Sunset Dream Homes Mother-in-Law Apartment, AL-17-017

Please accept the following comments from El Paso County Public Health regarding the project referenced above:

PLOT PLAN/SITE PLAN

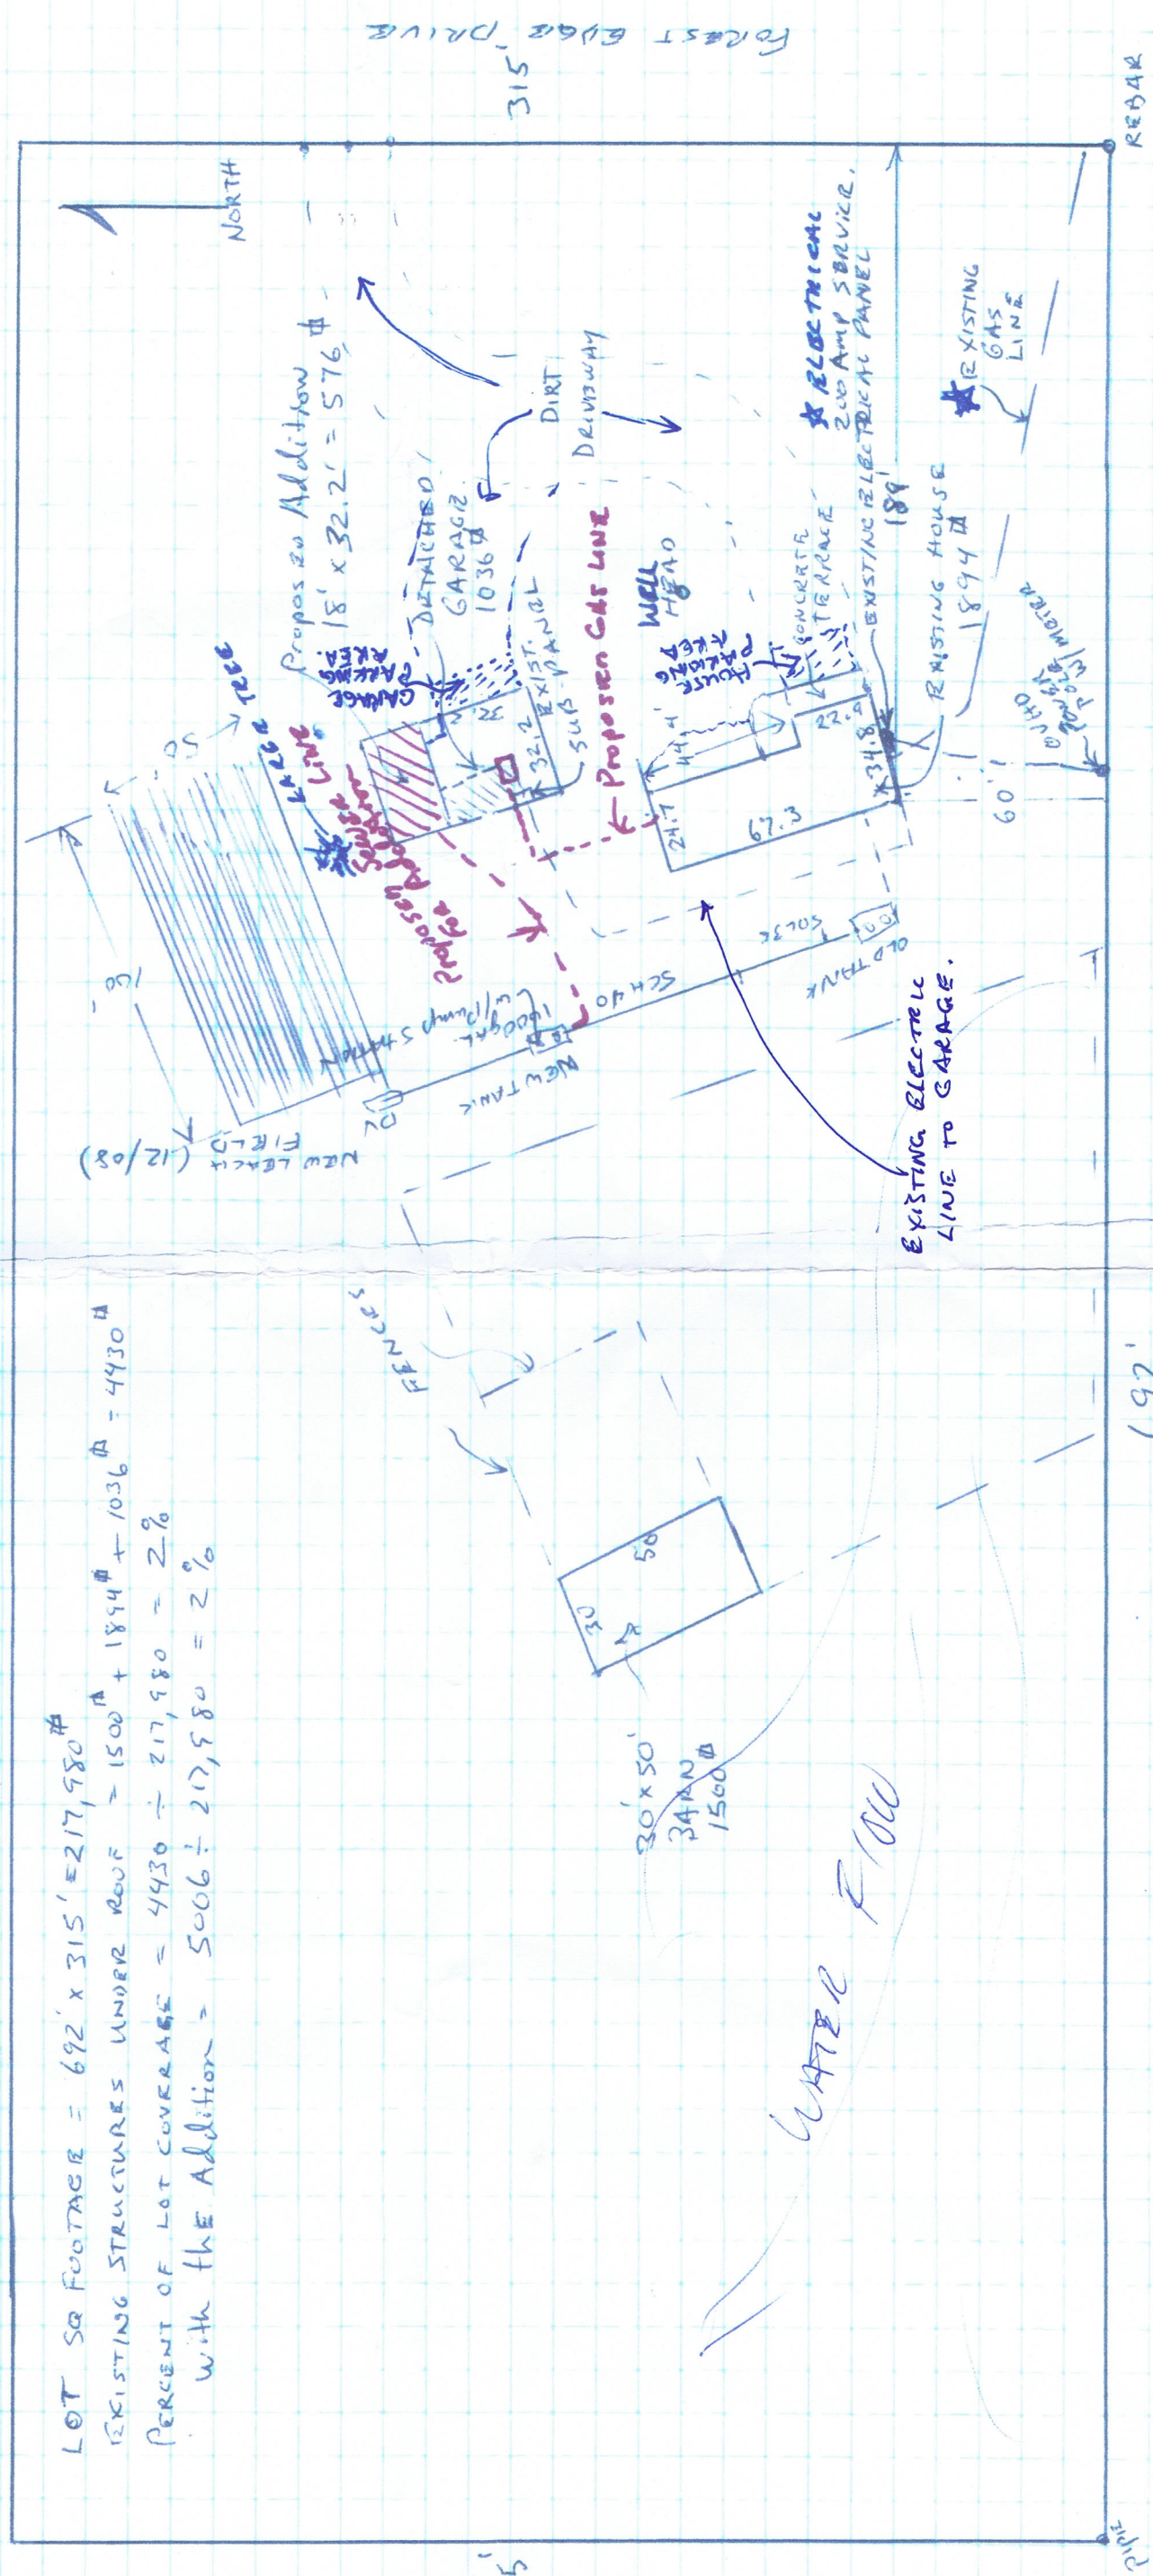
- **An OWTS Major Repair Permit may be required by El Paso County Public Health for the installation of a new 1,000 gallon septic tank for the apartment, the new building sewer line from the proposed apartment and the possible addition of more soil treatment area for the increased wastewater flow from the new apartment.**

- **A Colorado Registered Professional Engineer must evaluate the existing designed OWTS and the proposed addition of wastewater from the 2-bedroom apartment. The OWTS evaluation must be submitted to El Paso County Public Health for review and approval. There may be other options for wastewater service for the apartment such as a new separate OWTS for the proposed apartment vs. connecting to the existing designed OWTS.**
